Address: Virginia Lea, East Avenue, Huddersfield, HD3 3LW

Application number: 2026/91314	
What is the application for?:	Erection of detached supported-living dwelling with associated access, parking,
Address of the site or building:	Ash Meadow, East Avenue, Lindley, Huddersfield, HD3 3LW
Postcode:	HD3 3LW

title:
 Proposed Driveway Strategy

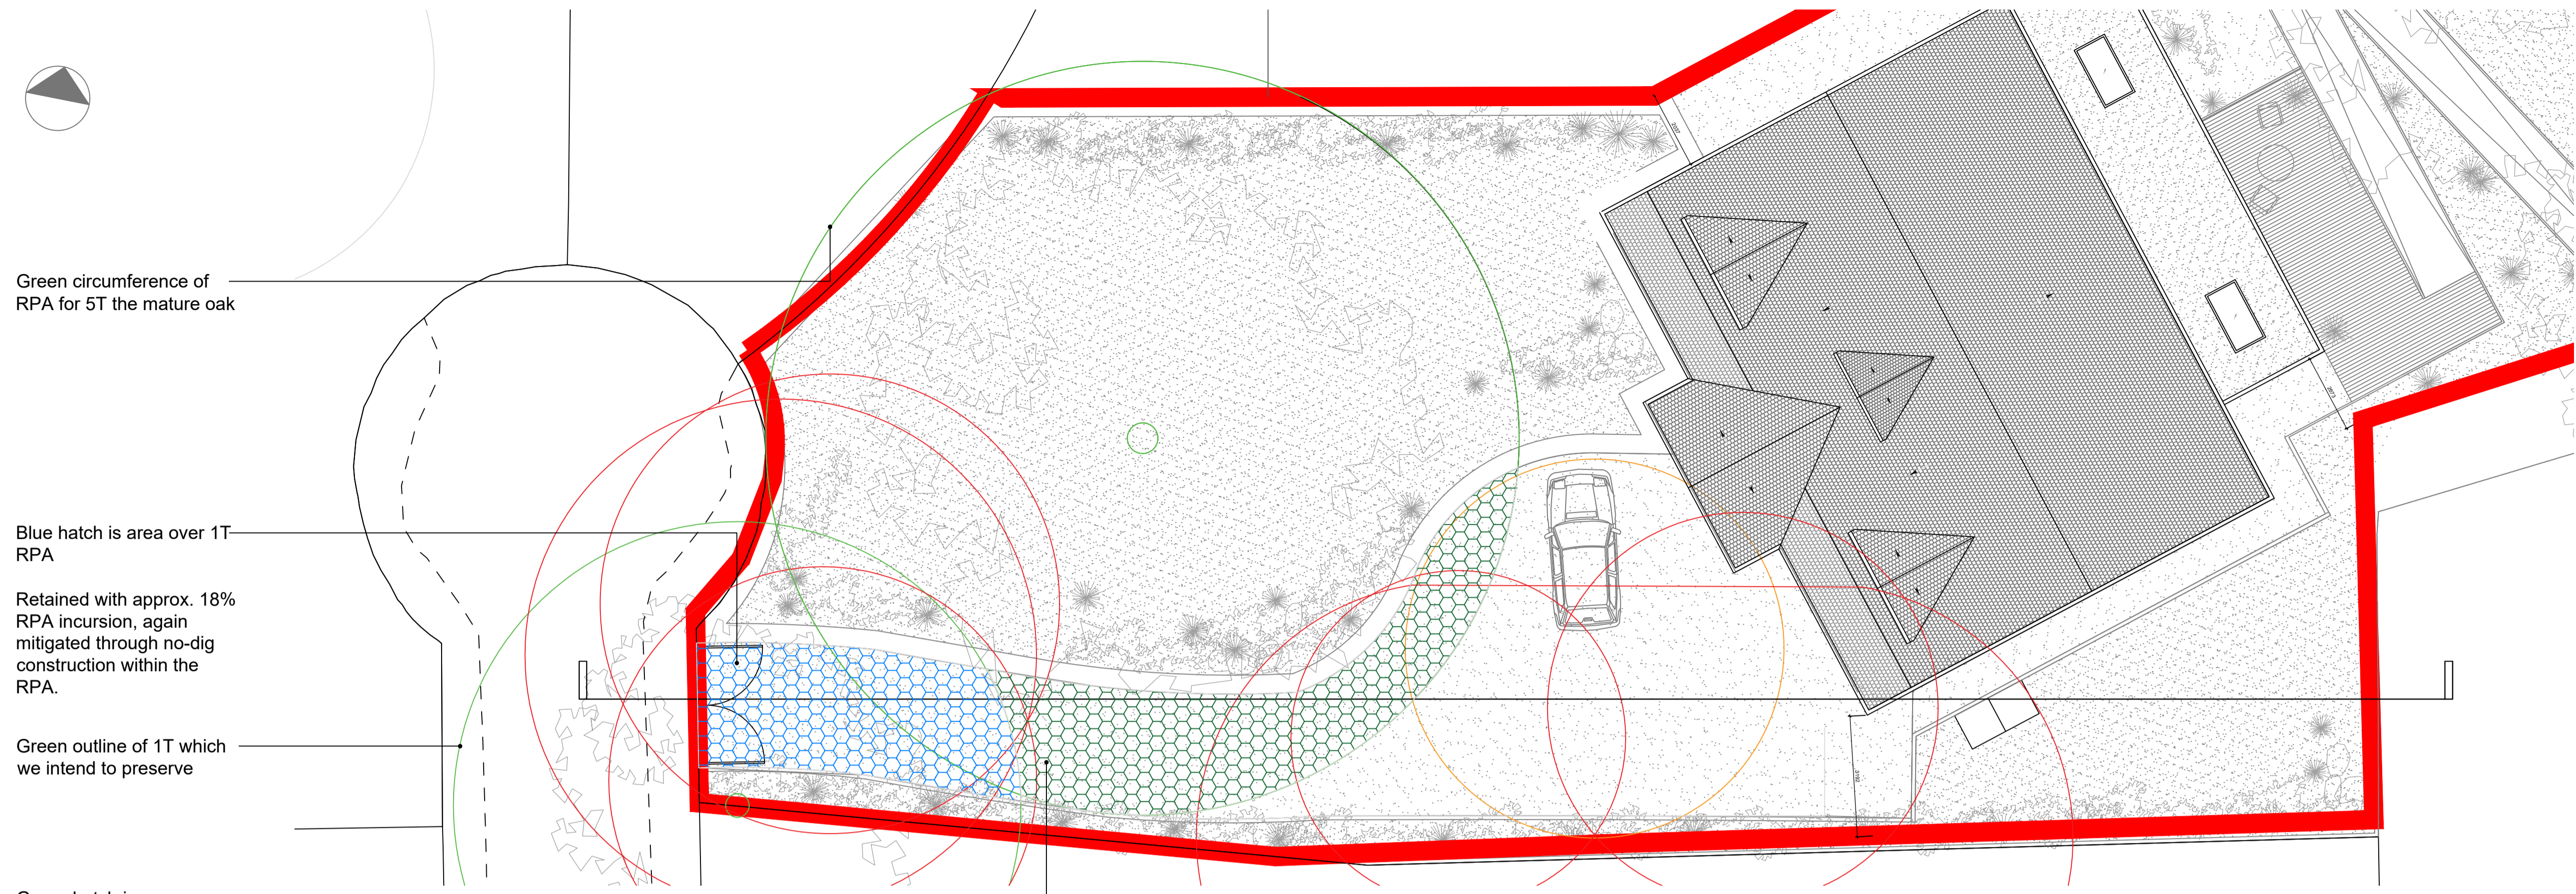
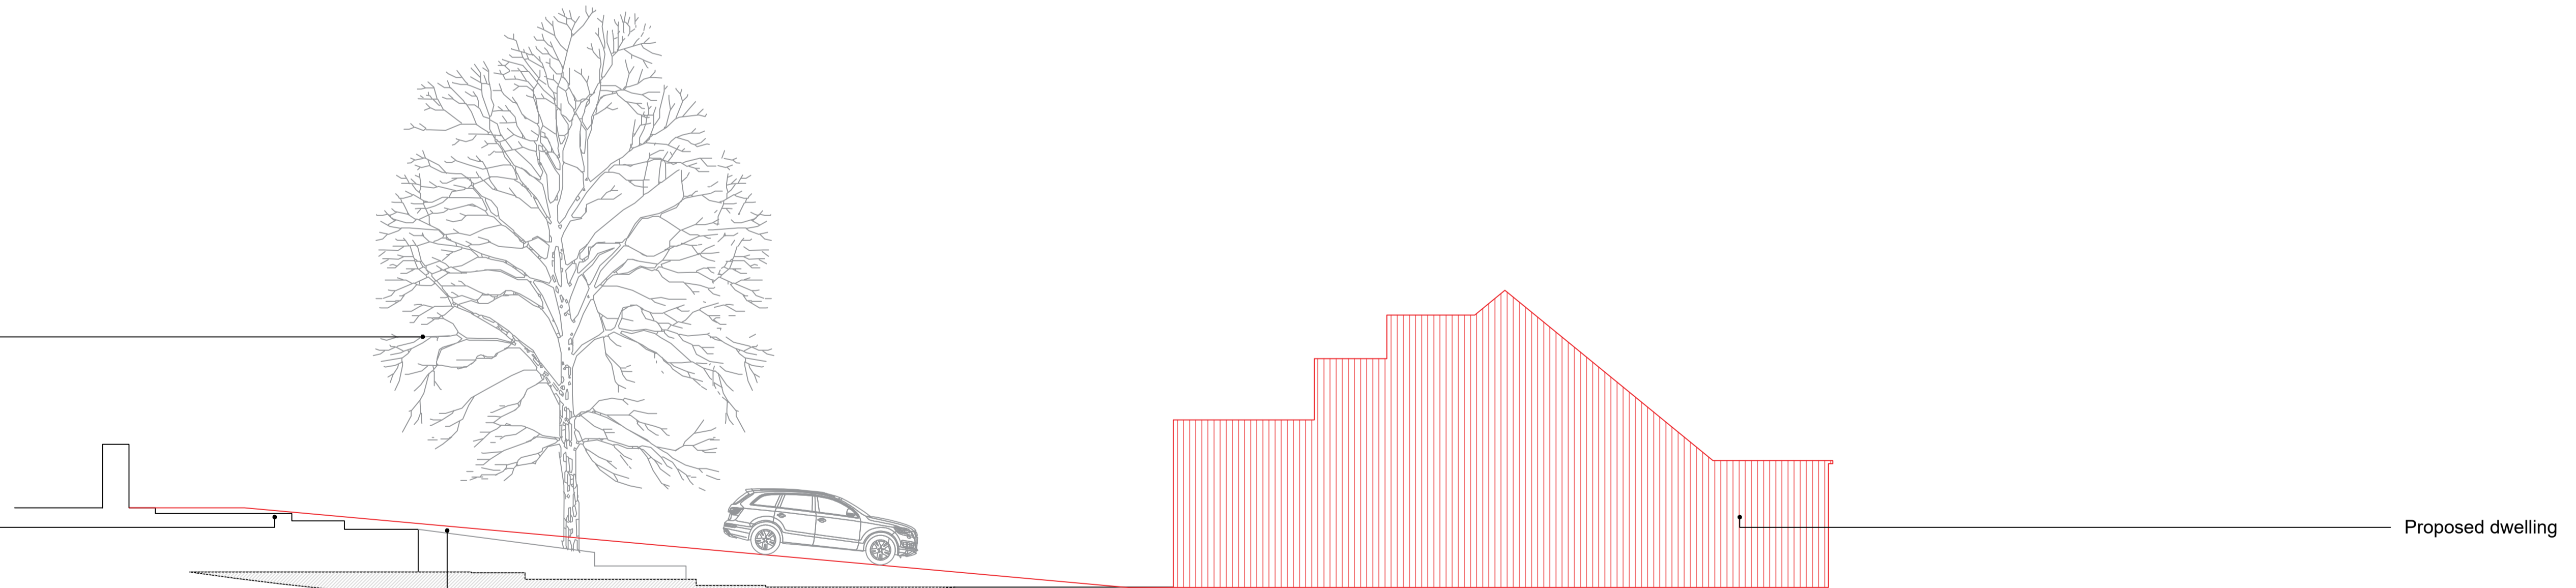
Type of comment: An objection	
Do you wish your comments to be published on the website anonymously?	No
With reference to Planning Application 2026/91314, we have the following objections, all related to the proposed access to East Avenue as follows: 1) The new opening is directly opposite our house Virginia Lea, clearly visible from inside the house and from our garden. 2) The turning out of the drive will be extremely tight if at all possible since the proposed drive is at an acute angle to East Avenue. reference drawing 2504-GA-120 3) The proposed drive will result in removal of several mature trees, 3 of the them are directly on East Avenue (highway). This will impact the general appearance of the avenue and well as impact on wildlife. 4) The opening will remove the only safe parking place for visitors to the houses Ashmeadow, Virginia Lea and The Orchard. Our suggestion is to have as shared drive with the existing house Ashmeadow, going from left of the Oak tree to the proposed dwelling. This would negate all 1-4 of the above objections.
